App no: 25.0799

Address: The Tyremen 28-30 Parson Lane Clitheroe

Proposal: Approval of details reserved by conditions 3 (Materials), 4 (Rooflights), 5 (Boundary Treatments), 7 (Highways Works), 10 (Drainage), 11 (Levels) on planning permission 3/2023/0789.

Client Hollinrake Developments Limited		
Project Proposed Residential Development at The Tyremen 28 - 30 Parson Lane Clitheroe BB7 2JP		
Drawing Title Proposed Site Plan and Footpath Details		
Scale 1:20/100 @ A2	Date Sep 2025	Drawn LFR
READ DESIGN LTD		
168 - 03 B

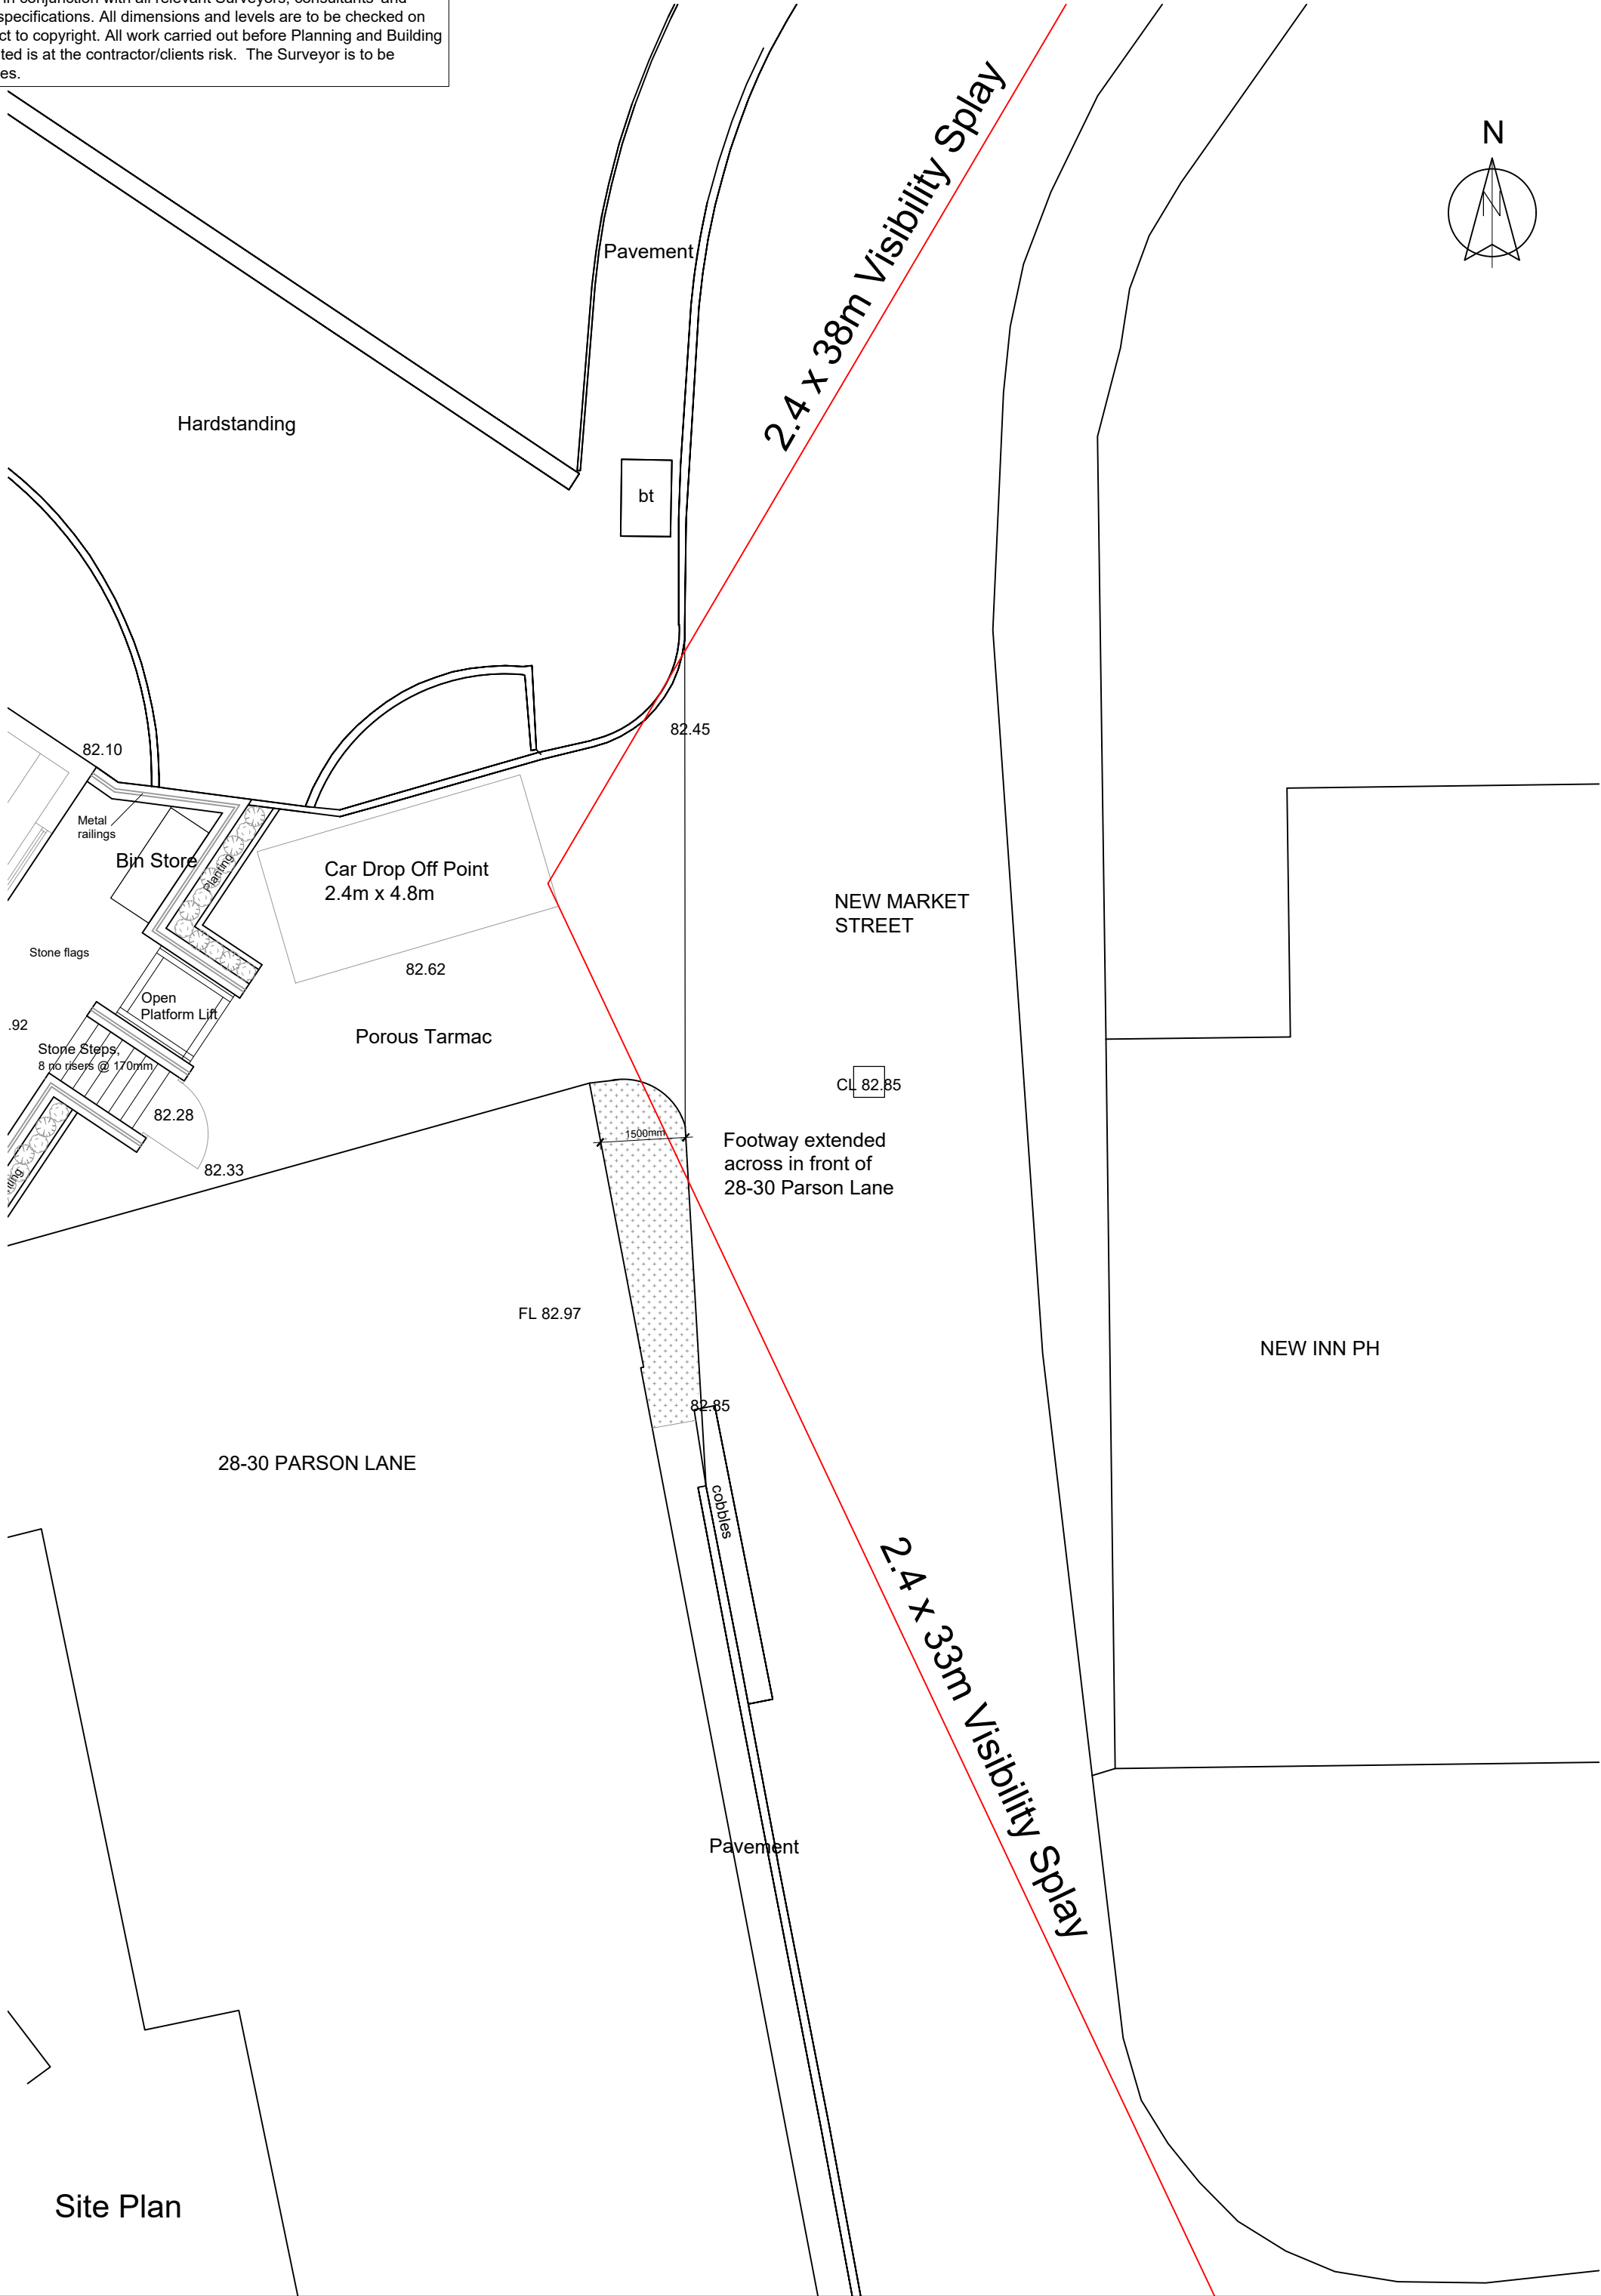
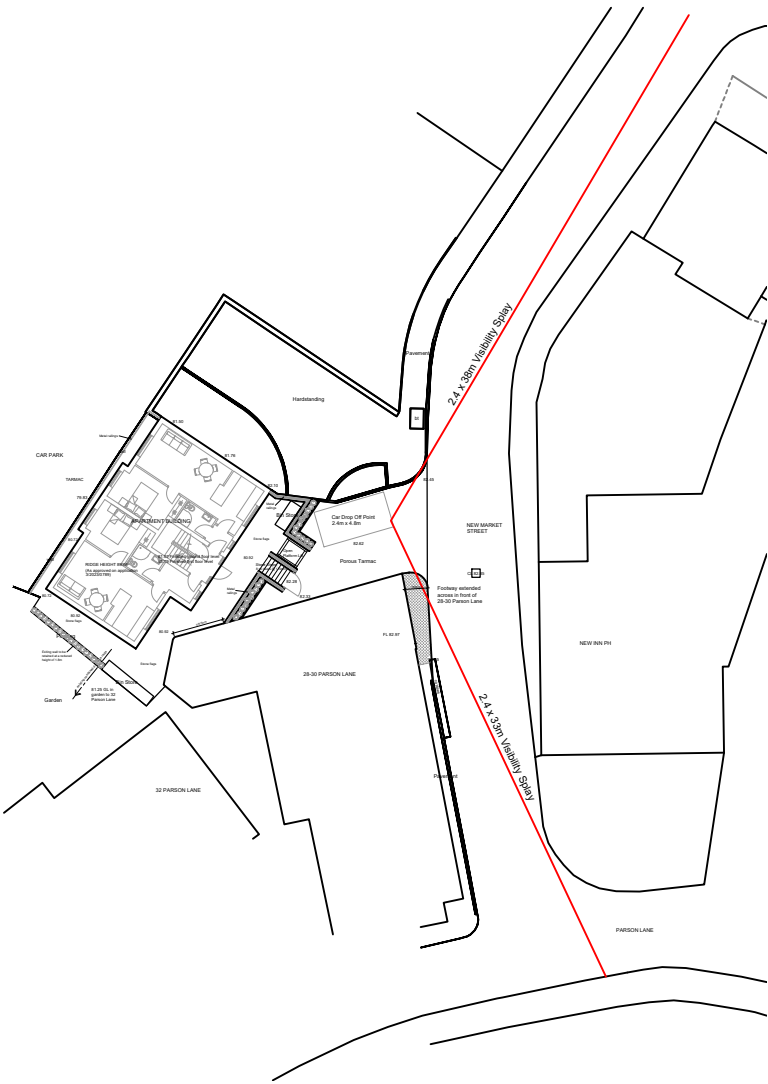
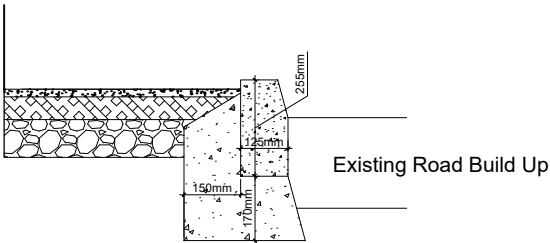
Within 3 months of commencement a scheme for the off-site highway works shall be submitted to and approved by the Local Planning Authority. The works shall include the following and be implemented prior to the first occupation of any residential unit. 1.A new footway on the west side of Parson Lane, in front of 28-30 Parson Lane is requested to link to the existing footway network to the north. 2.Pursual of a traffic regulation order on the west side of Parson Lane.

The drawing 168 – 03 Rev C has been assessed by Lancashire County Council under the S278 process and we are satisfied that the condition can be discharged.
